HINCKLEY NATIONAL RAILFREIGHT INTERCHANGE

*Written Representation (ref.
HRFI 20040018) on behalf of
Blaby District Council in
response to Tritax Symmetry
(Hinckley) Limited submission of
a Development Consent Order
(ref. TR05007)*

Edward Stacey Deadline 1 – October 10, 2023

Map 4.3: Option 1 – Brooksby

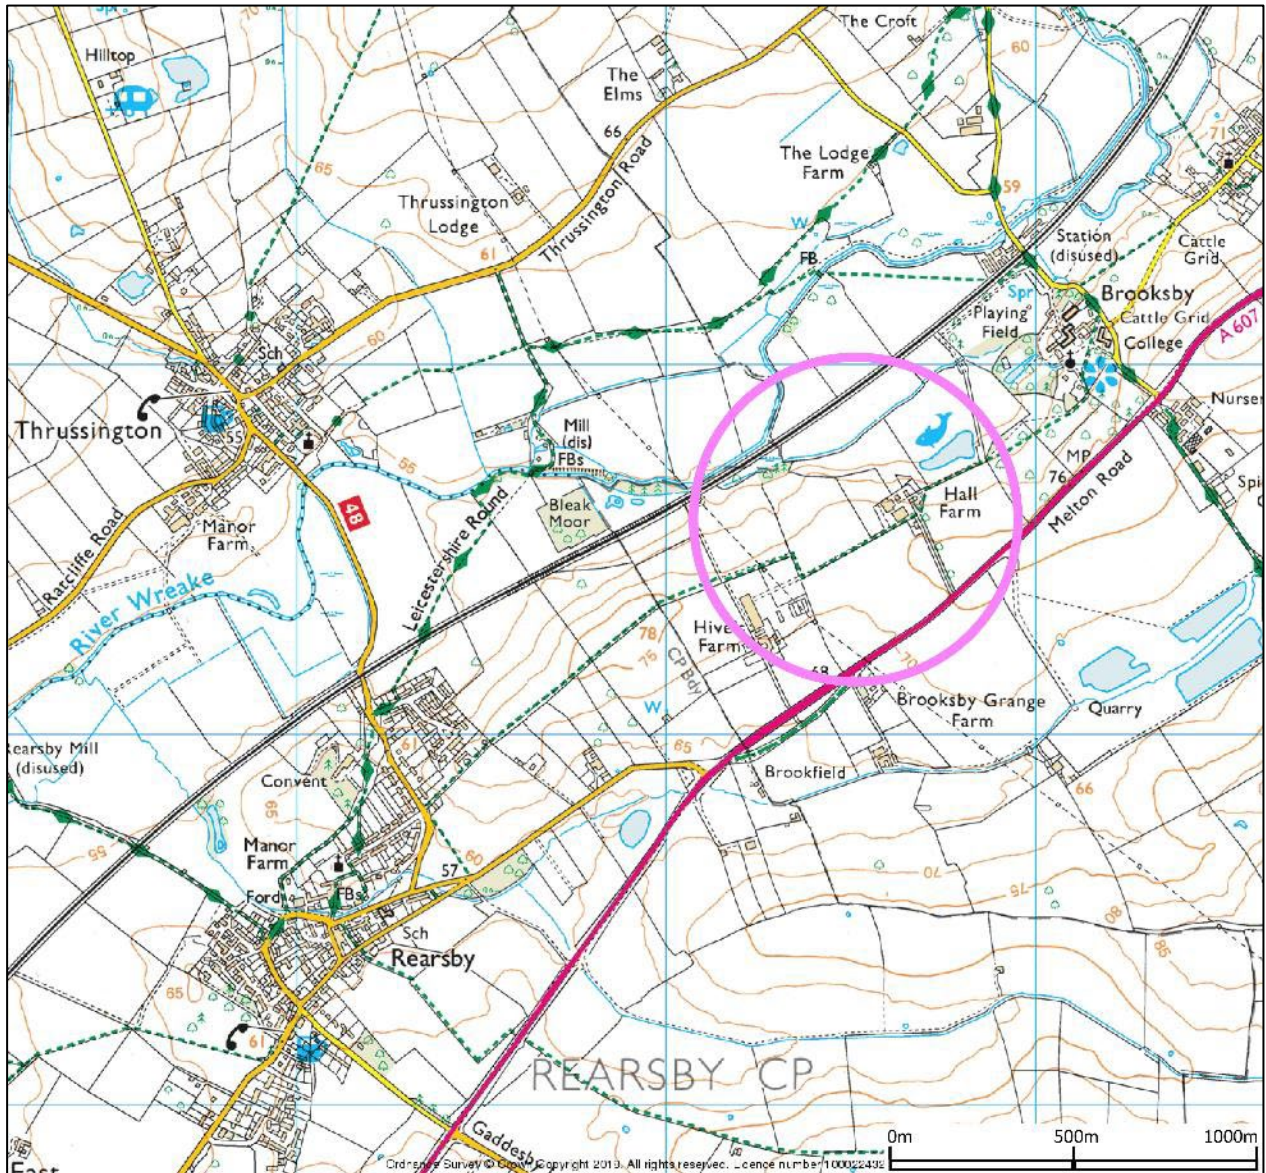
- 3.7 In response to the Applicant's statutory consultation BDC raised concerns in respect of the relevance of site options 1 – 3 (Brooksby, Syston Fosse Way Junction and Syston Barkby Lane). Whilst the options are all to the north of Leicester and do not accord locationally with the *Leicester and Leicestershire Enterprise Partnership's Strategic Economic Plan 2014-20* (March 2014), or the options also do not correlate with the more recent *Leicester and Leicestershire Authorities Warehousing and Logistics in Leicester and Leicestershire: Managing growth and change* (amended March 2022), it does not mean that such sites should not be considered. Moreover, additional comment was provided in respect of the potential ability to locate facilities on land to the north of Stoney Stanton or between Hinckley and Nuneaton to the south of the A5. Other than a cursory comment on alternative sites, no enhancement of the original site assessment appears to have been undertaken by the Applicant. The assessment provided is therefore still considered inadequate by BDC.
